Our Ref: R/66/20/PL 23-03-2020

Residential development consisting of 1 no new dwelling.

Land adjacent to 19 The Bramblings Rustington

DRAWING TITLE			
Site Plan, Street Elevation Block Plan and Location Plan

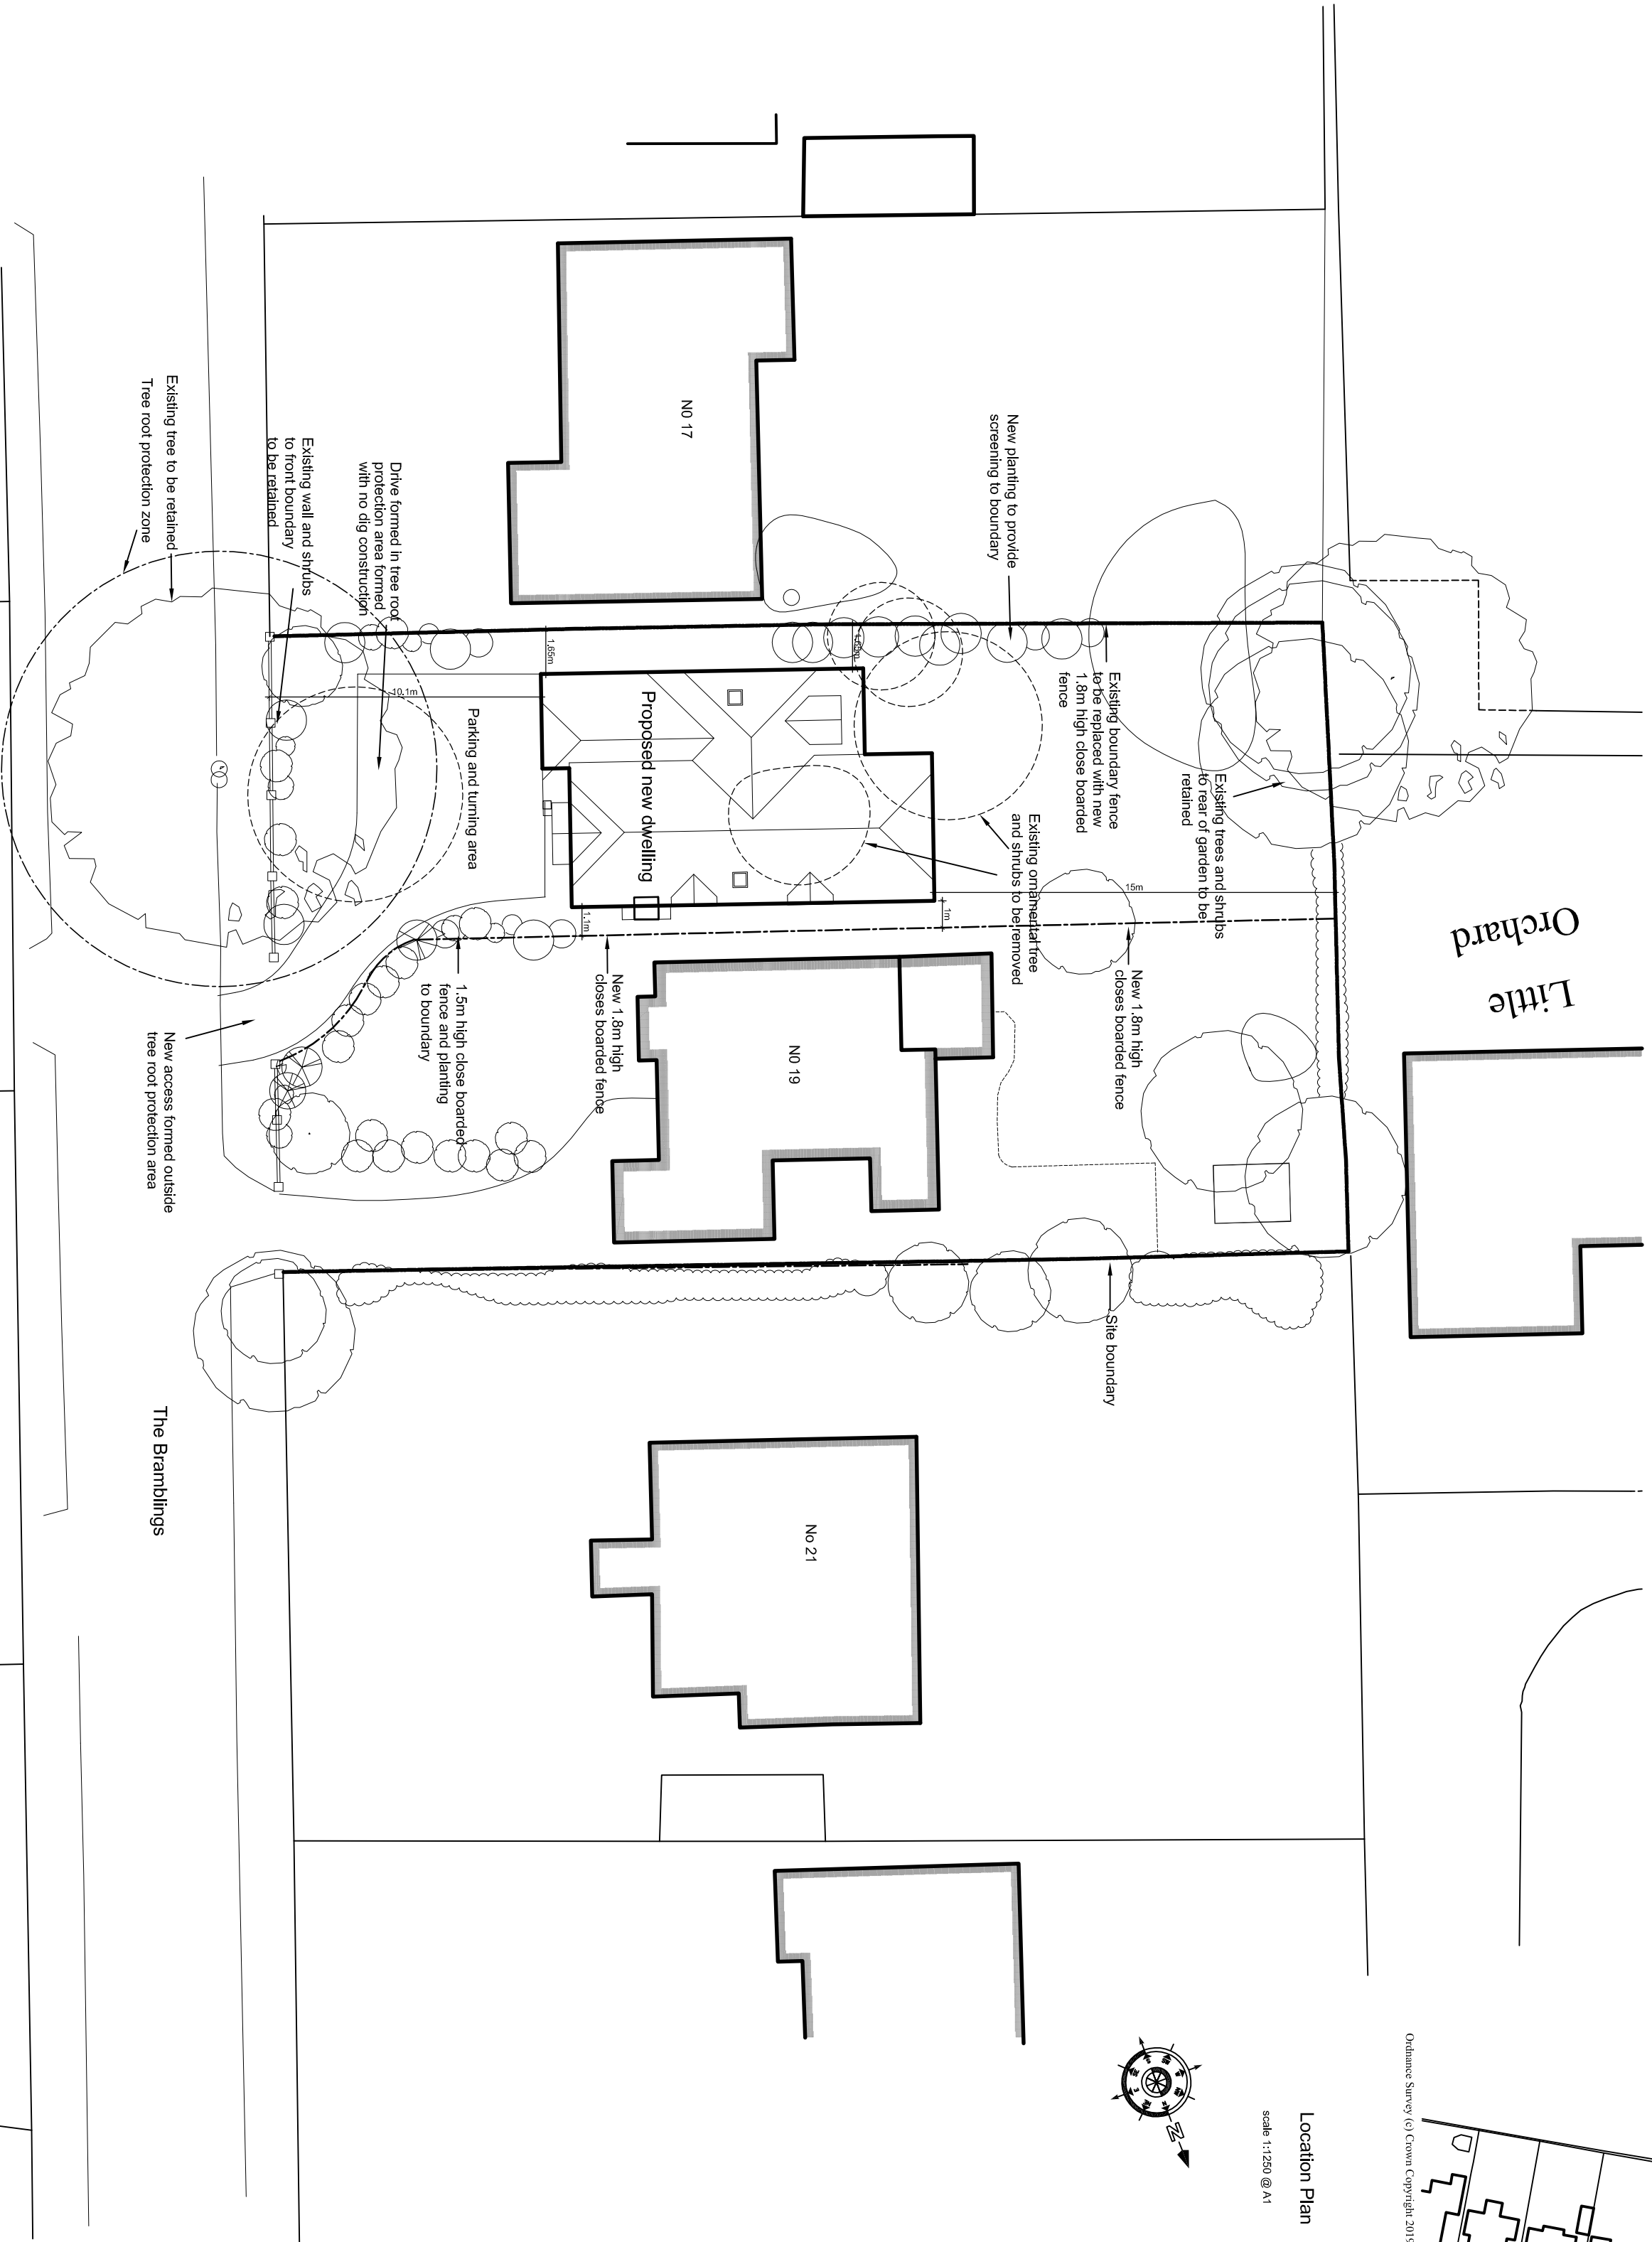
- 1) it breaks Sea Estate rules that properties must be 3 metres of the boundary.*
- 2) The road is narrow at 19 The Bramblings any vehicles parked there will cause difficulty to pedestrians as there is no footpath.*
- 3) It is a very small plot and a development of this size is totally disproportionate.*
